**From:** [Jeremy Larson](#)  
**To:** [Rachael Stevie \(CD\)](#)  
**Subject:** FW: BL-22-00001 Colazo  
**Date:** Friday, March 25, 2022 12:13:31 PM  
**Attachments:** [image001.png](#)

**From:** Kelee Hodges <kelee.hodges.pw@co.kittitas.wa.us>  
**Sent:** Thursday, March 24, 2022 8:09 AM  
**To:** Jeremy Larson <jeremy.larson@co.kittitas.wa.us>  
**Subject:** BL-22-00001 Colazo

ZEPEDA COLAZO PROPERTY

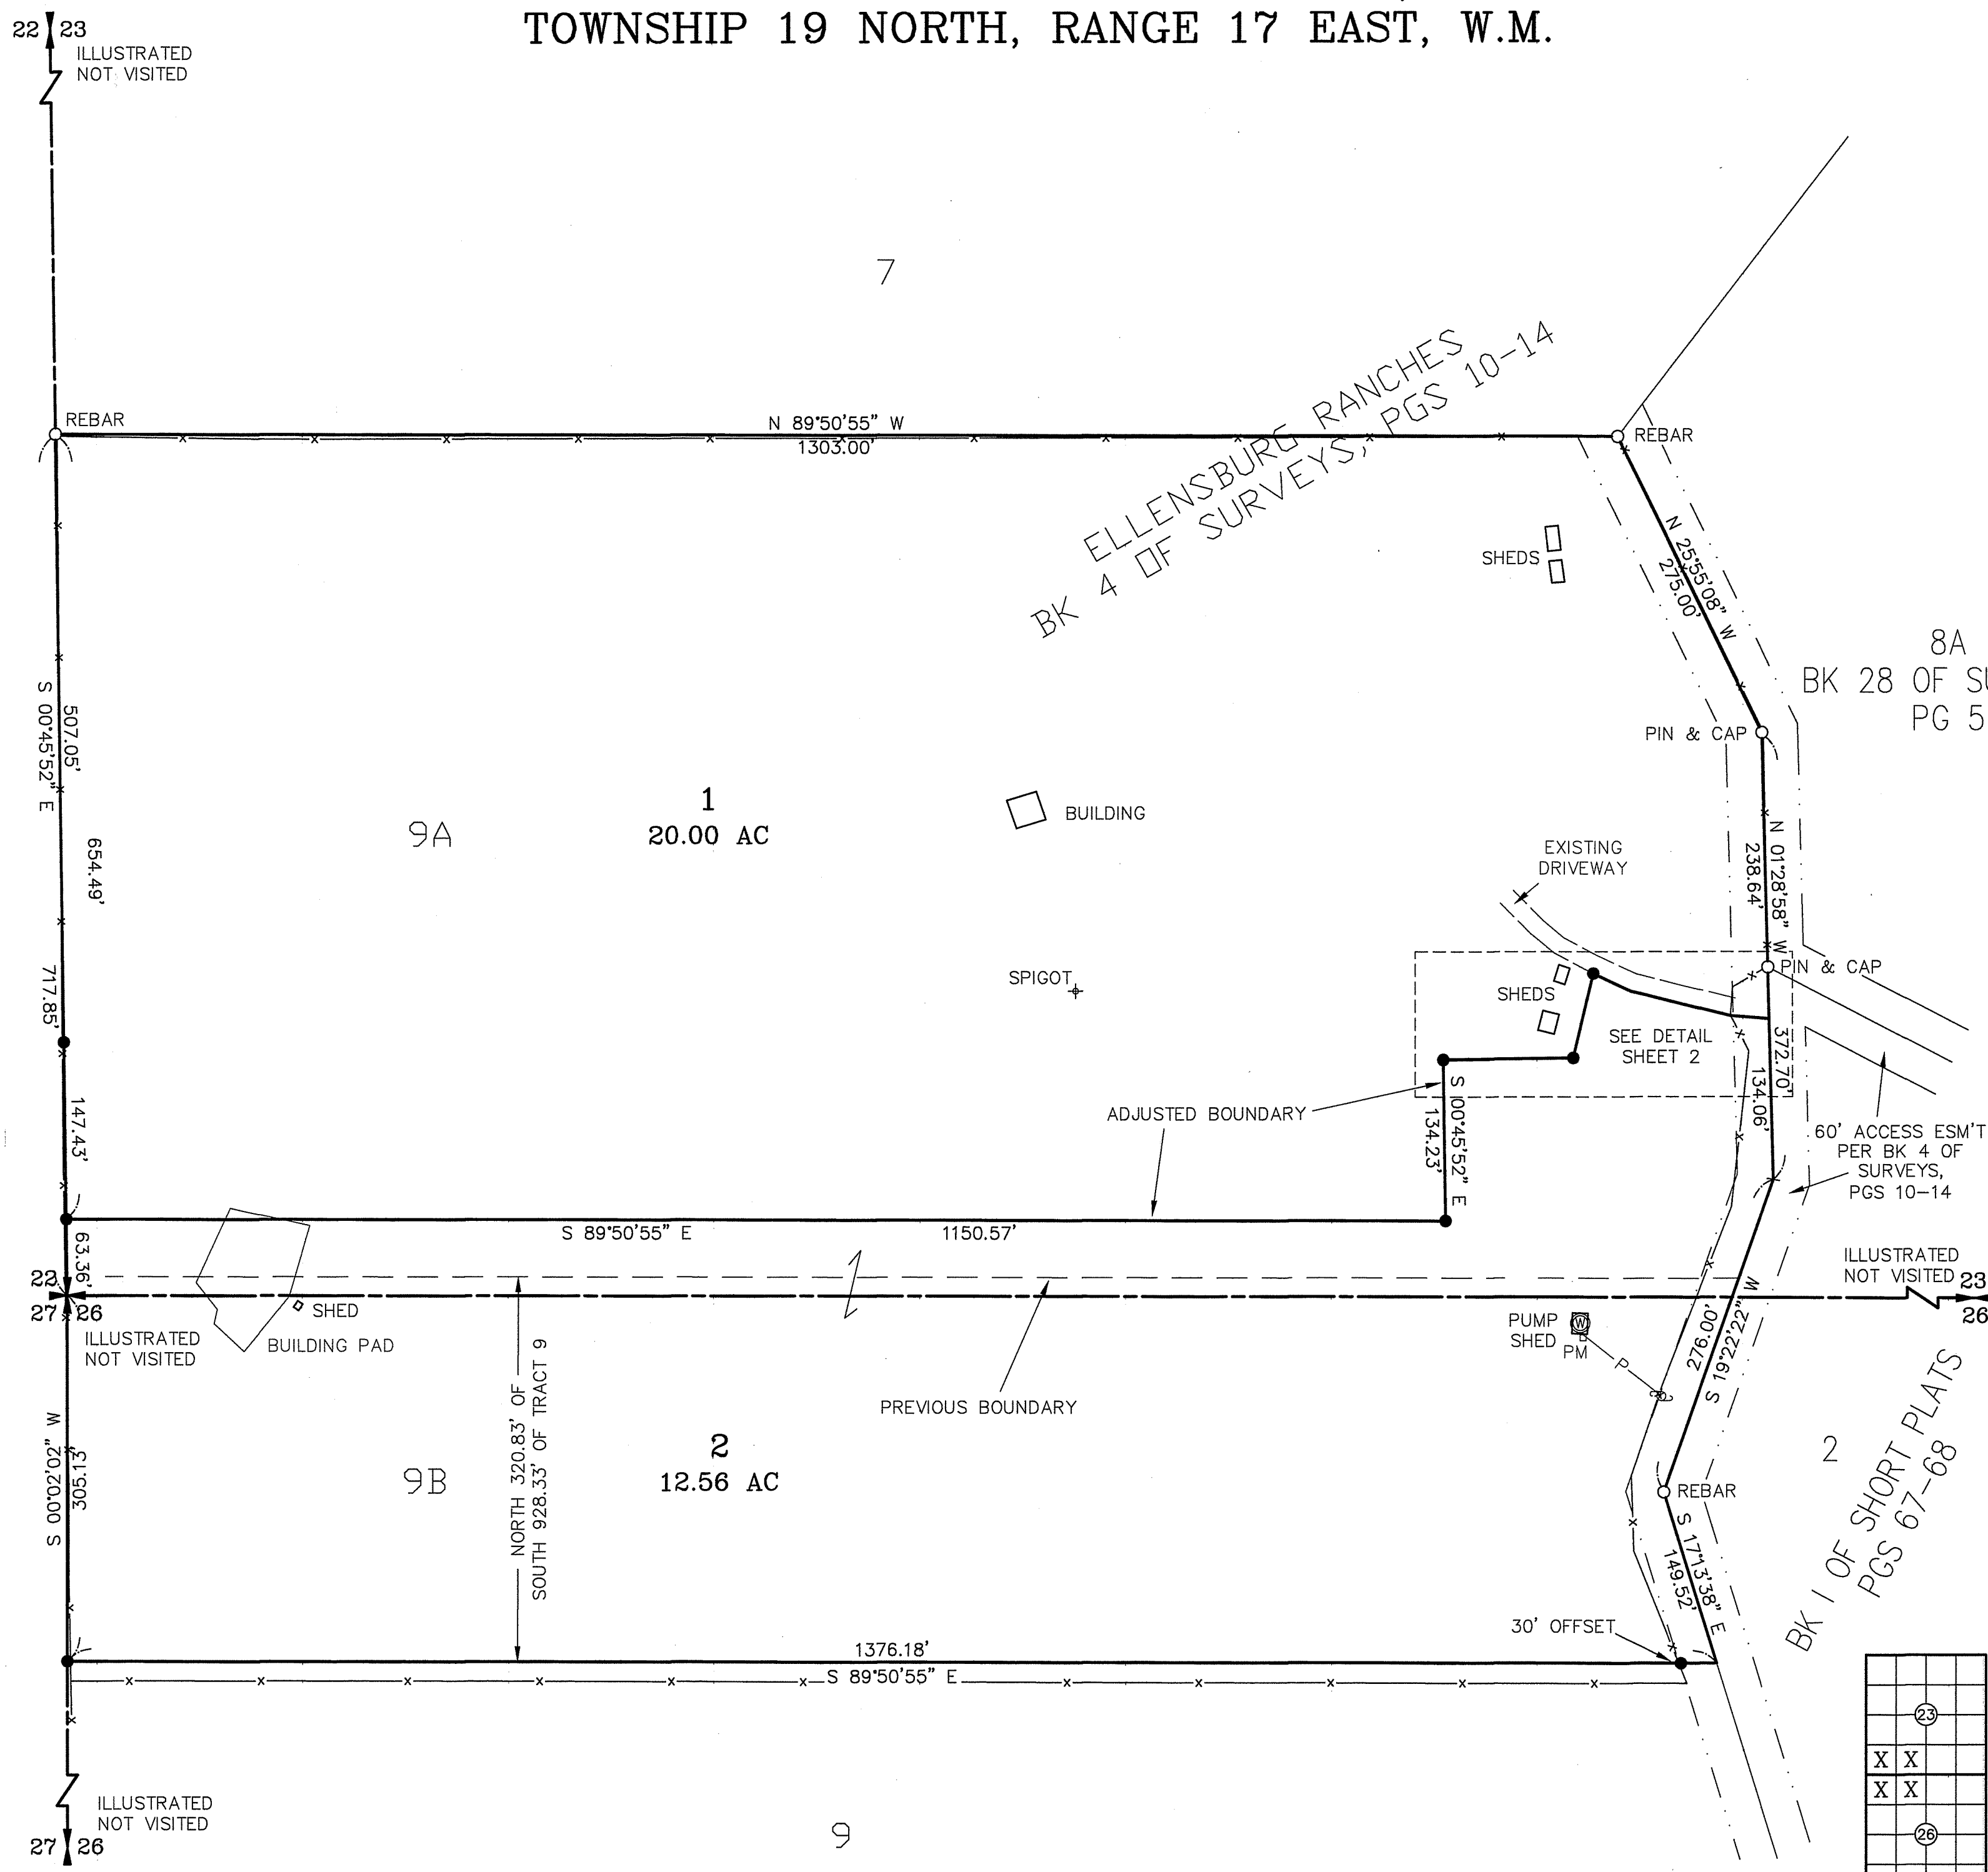
I received comments from Kelee Hodges yesterday on this. It looks like comments on this were required by 2/5/22... That said it just looks like an old concrete slab. I thought maybe it was a structure that was destroyed in the Taylor Bridge fire, but looking at old satellite photos I don't see any structures dating back to 1985.

Good morning! I wanted to reach out in regards to this BLA. While reviewing for survey comments, I noticed that they have a "building pad" noted on the map. This pad is on the boundary line for both lots. I noted it for survey but was not sure if this is something that you would also have comments for? It's not a building yet but looks like it may be in the near future?
